Proposed Lake Lothing Third Crossing (TRO10023)

Associated British Ports (20013261)

Response to the Applicant's Deadline 10 submissions and the Examining Authority's draft Development Consent Order

Scenario 2 - Two 50m vessels

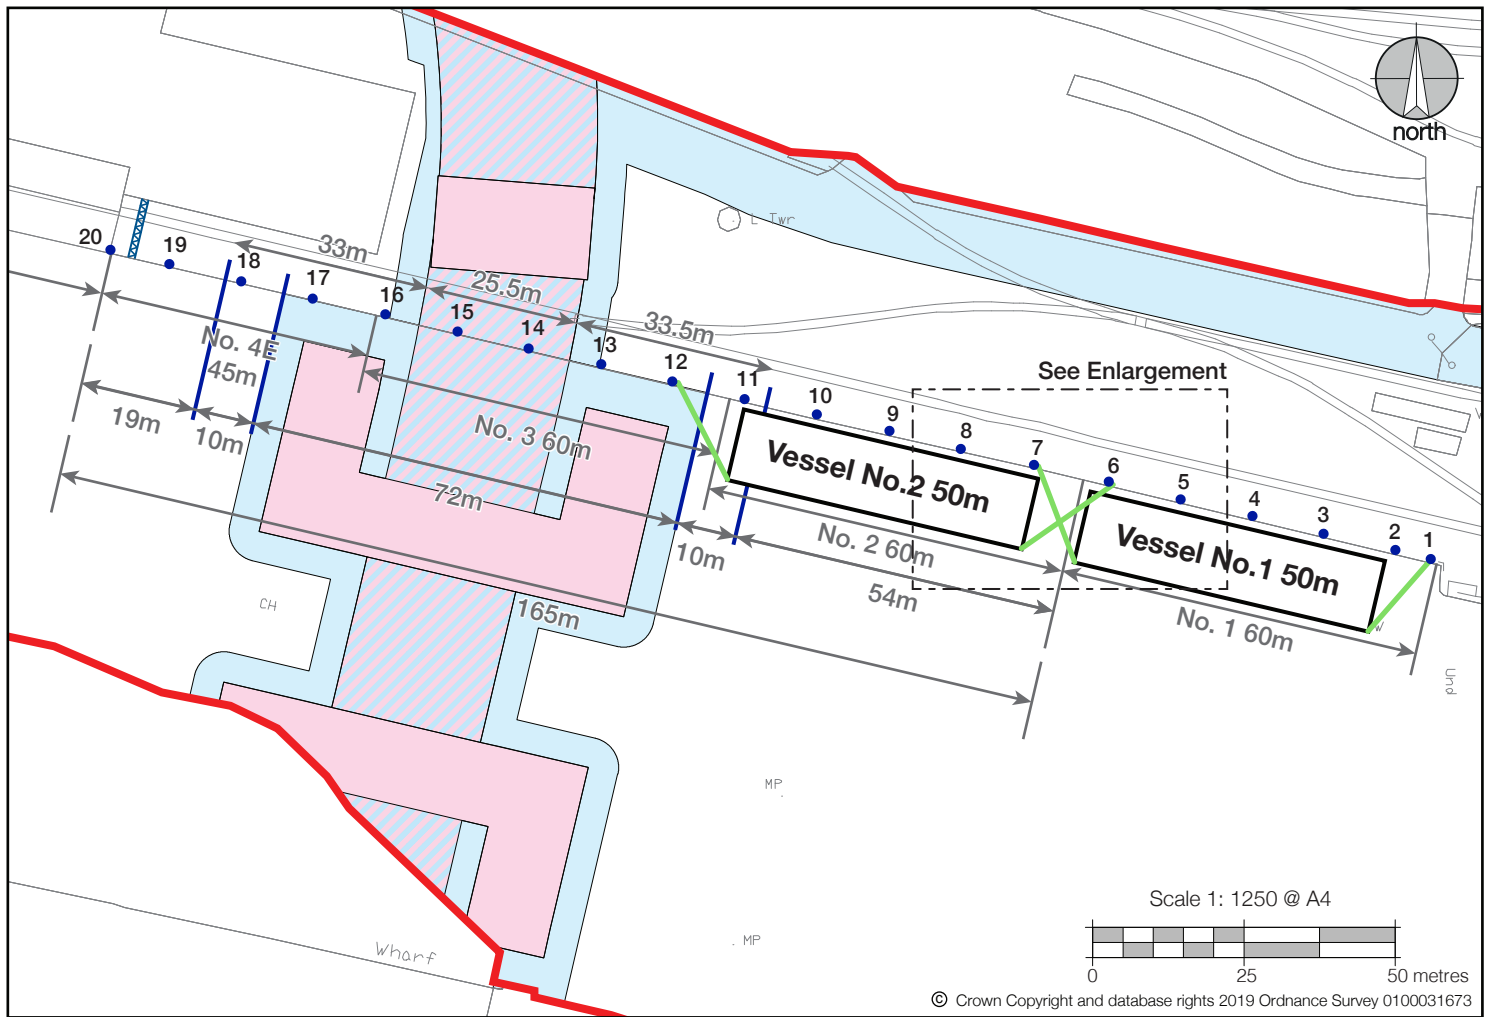
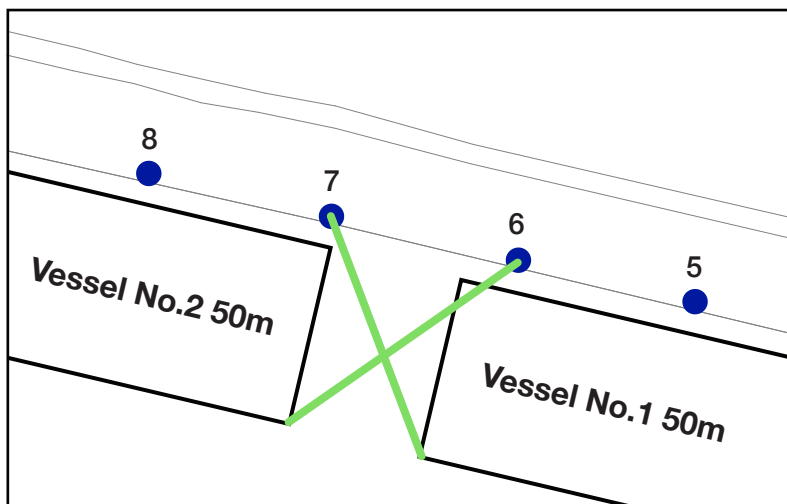
- 14.11 To clarify, ABP suggested that a 'sterilization' area of 50m measured from the edge of the bridge deck/roadway is an appropriate and reasonable buffer to maintain port security, and that a figure of 220m (as opposed to the Applicant's figure of 223m quoted above) is applicable when it relates to larger commercial (ISPS) vessels that are over 70m (and would be closer than 50m to the Bridge Deck). DfT agreed to this position on two separate occasions:
